## APPLICANT'S RESPONSES TO THE EXAMINING AUTHORITY'S SECOND WRITTEN QUESTIONS (EXQ2)

HyNet Carbon Dioxide Pipeline DCO

**Document Reference Number D.7.48**

DATE: July 2023

DRAWING NUMBER
EN070007-APP-ES-17.4-Sheet 1

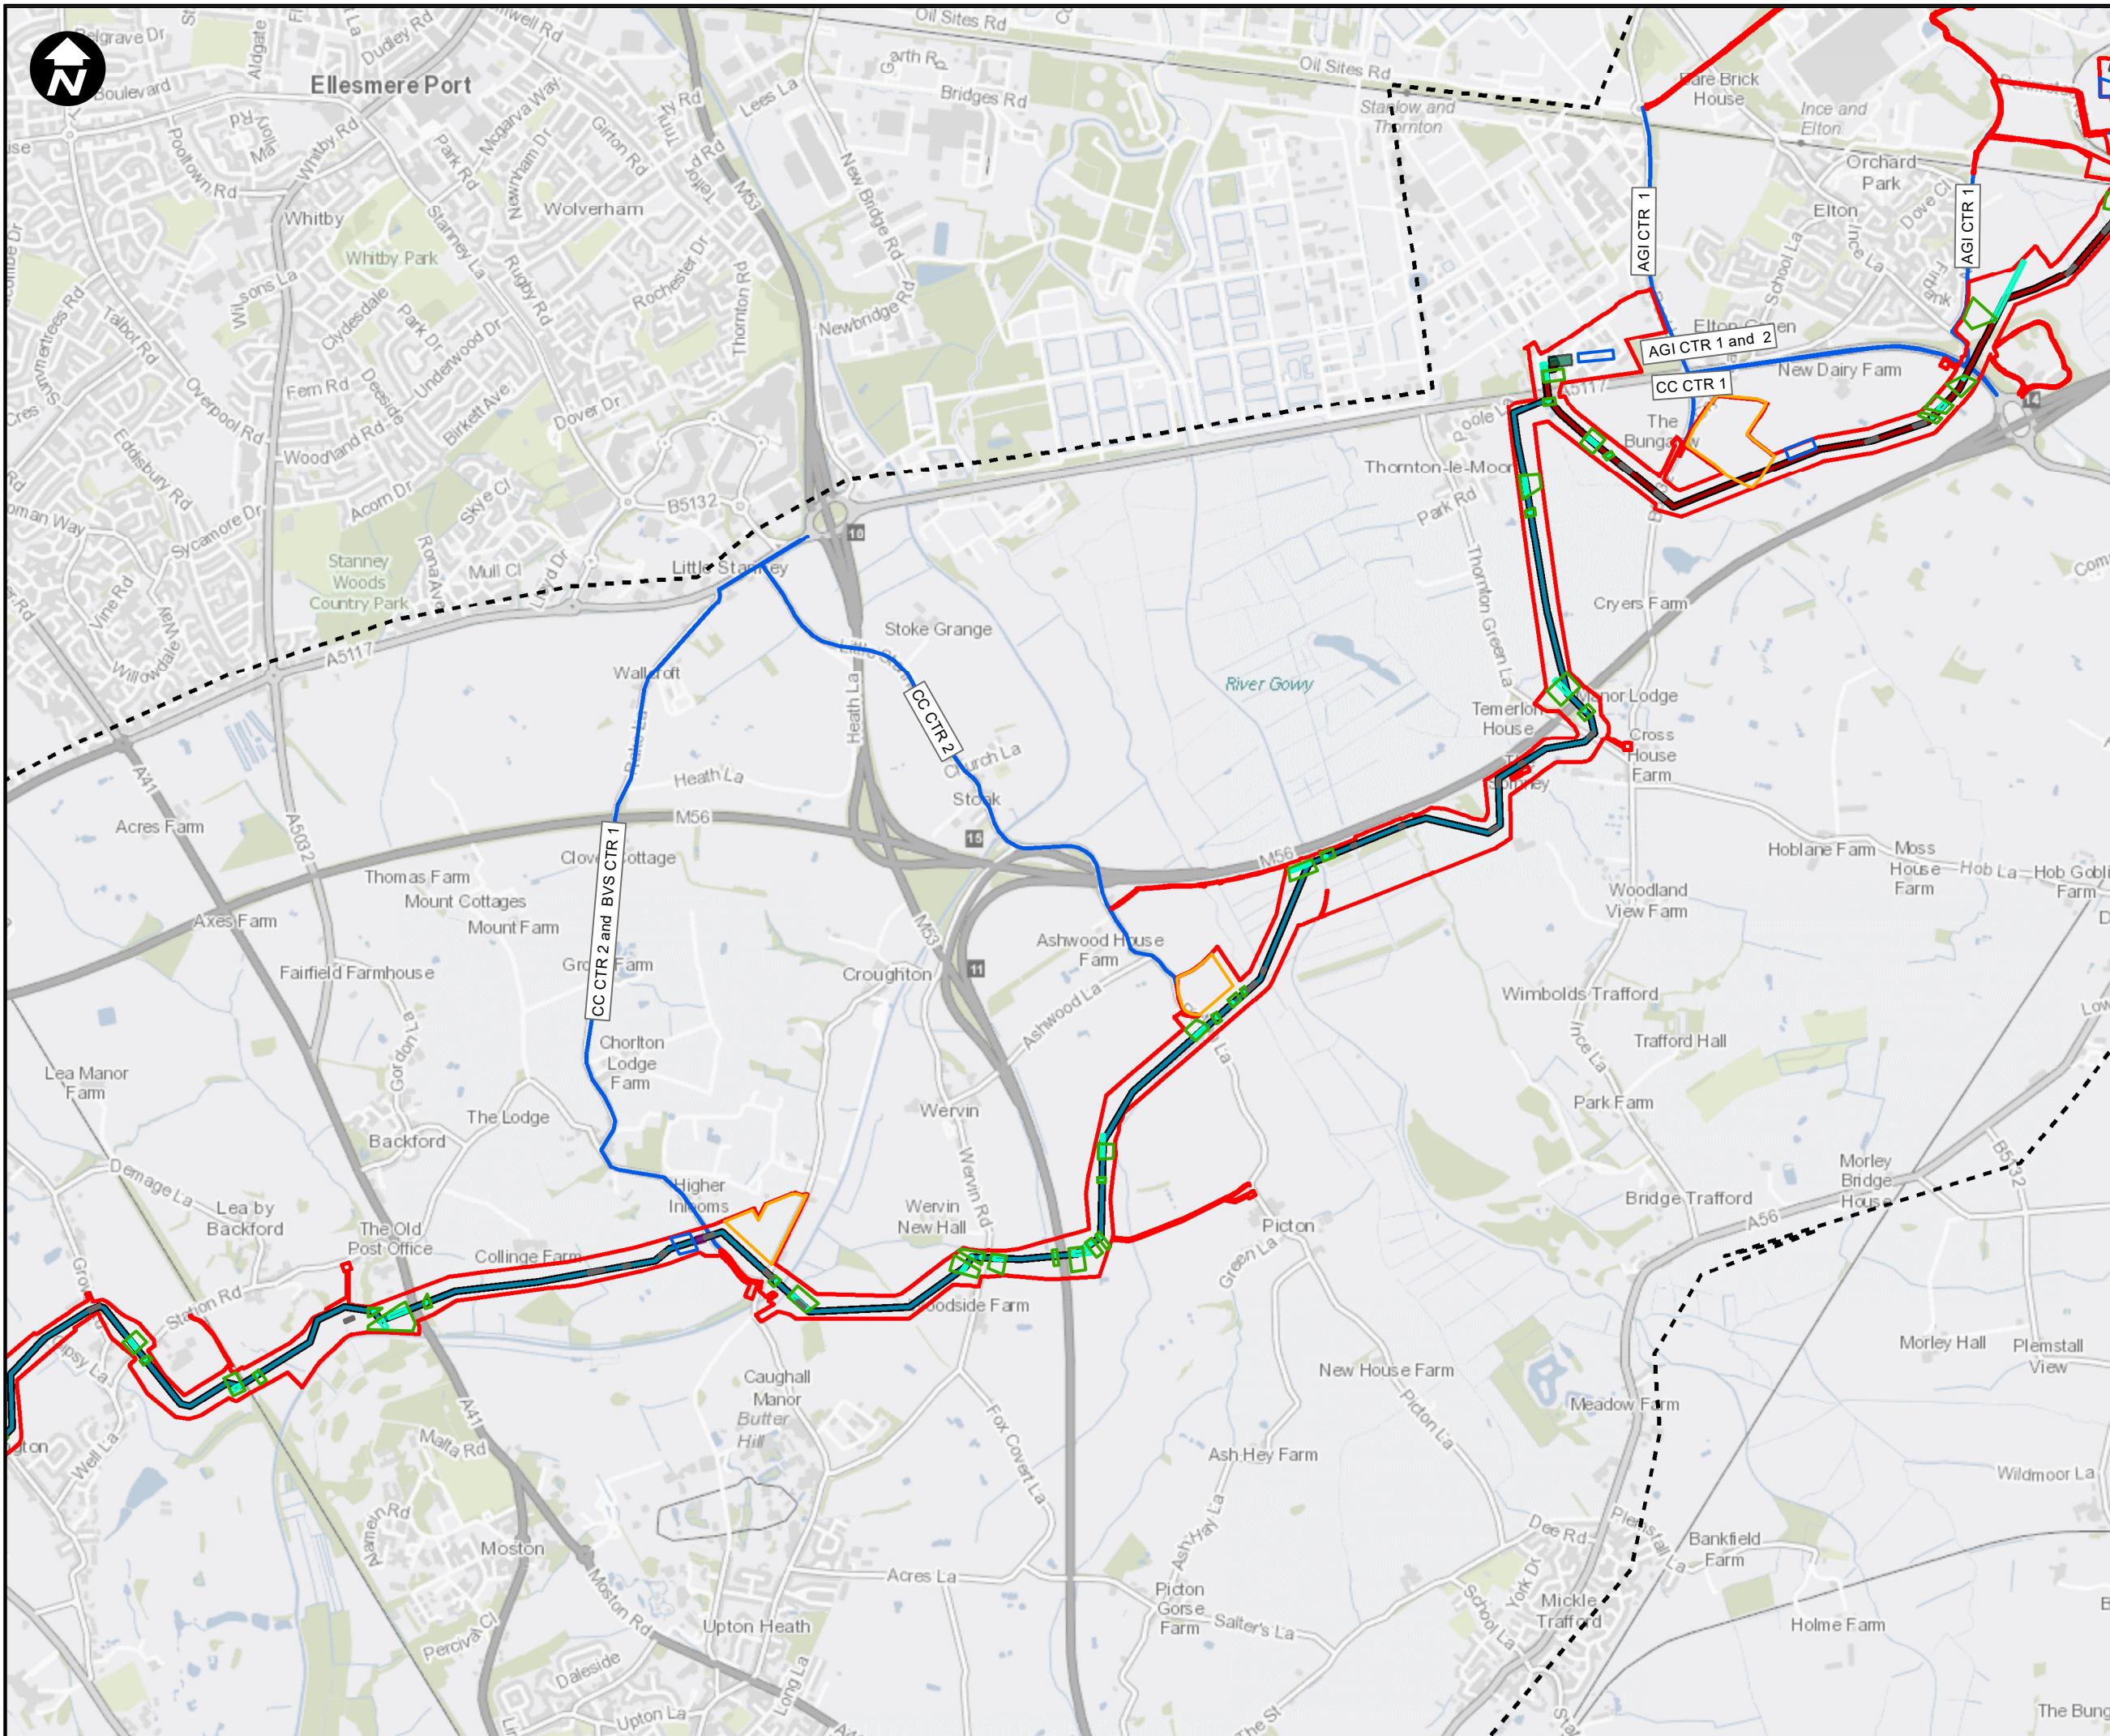
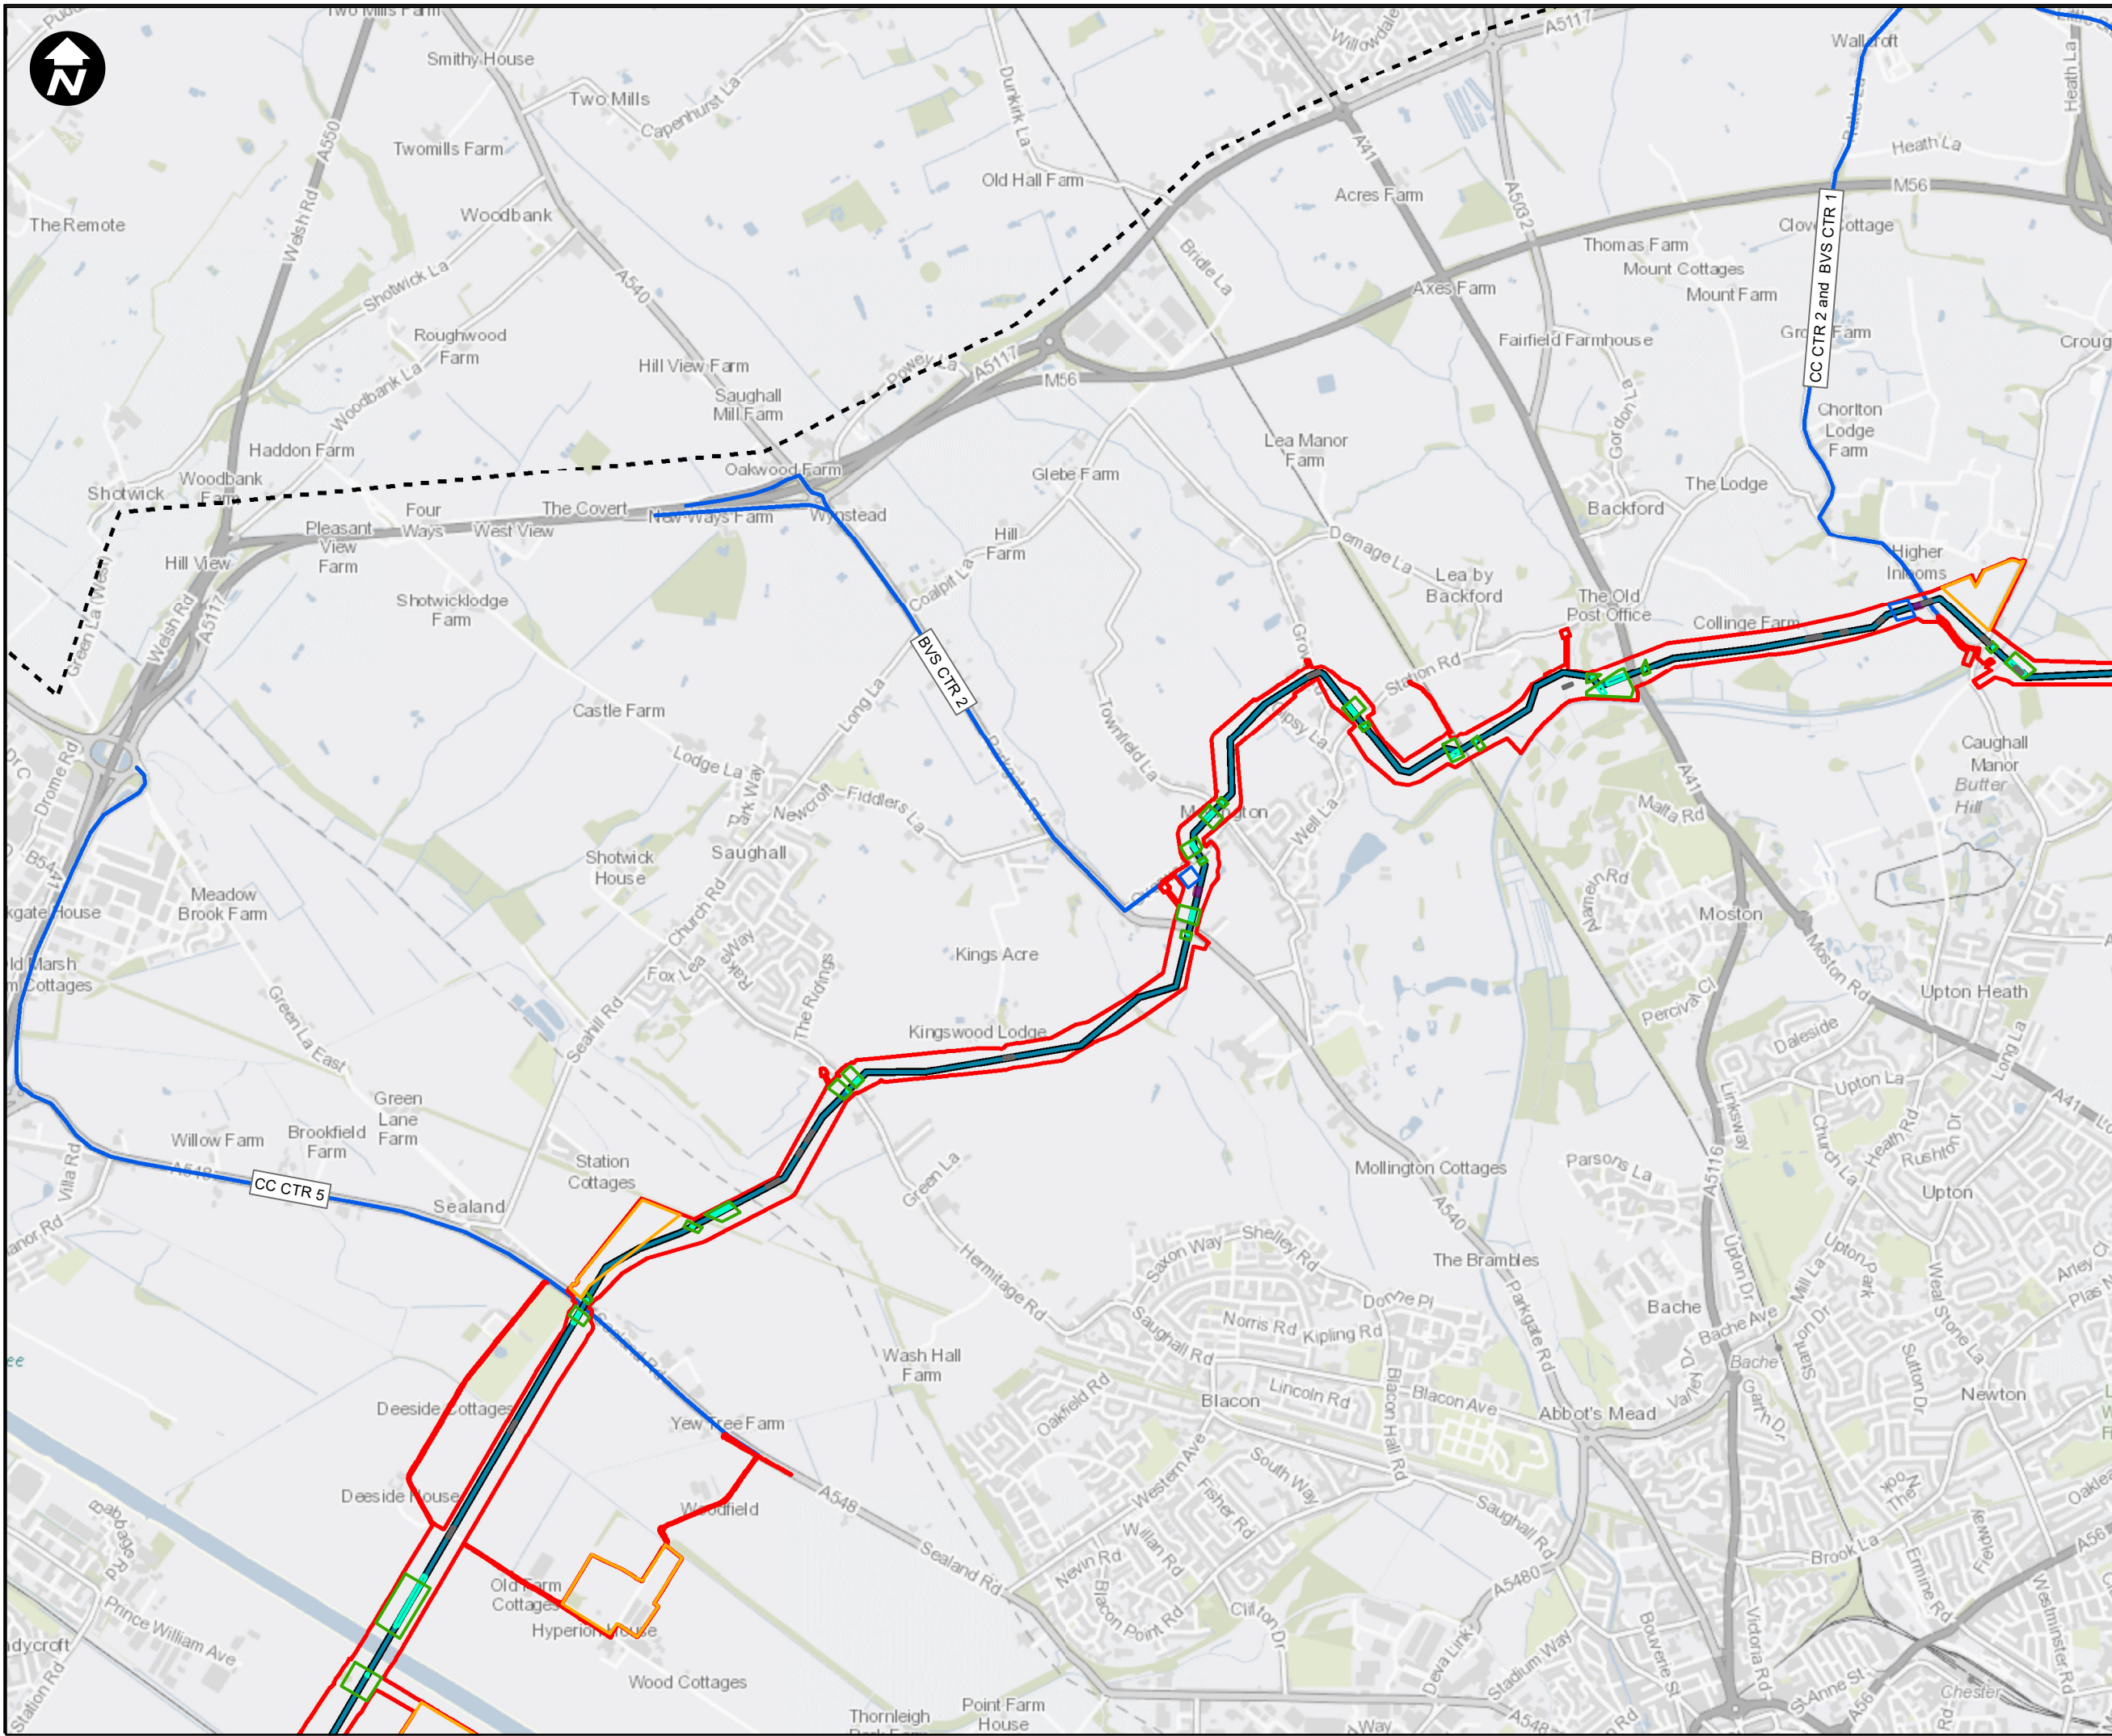
Q2.1.3	<i>Clarification</i> Applicant	Figure 17.4 (Construction Access) [CR1-092] is unclear in regard to AG1 CTR1, which appears to be obscured by the red line Order boundary. Please review and amend, if required.	<p>AG1 CTR1 runs along Pool Lane to the junction with Grinsome Road and along Ash Road to the rail bridge at the entrance to Encirc. The construction traffic route is then off public highway within the Order Limits. The blue line denoting AG1 CTR1 in Figure 17.4 (Construction Access) <b>[REP4-227]</b> is erroneously shown along Grinsome Road. This will be amended prior to the end of Examination.</p> <p>AG1 CTR1 is also erroneously labelled in Figure 17.4 (Construction Access) <b>[REP4-227]</b>, the label should read 'AGI CTR1'. This will be amended prior to the end of the Examination.</p>
Q2.1.4	<i>Clarification</i>	Peel NRE references "Future Planned Infrastructure" in its submissions. Can it elaborate on what this means? (e.g. Is it referring to an existing allocation in the	The Applicant would refer the ExA to the current position captured in the following Statements of Common Ground (SoCG's):
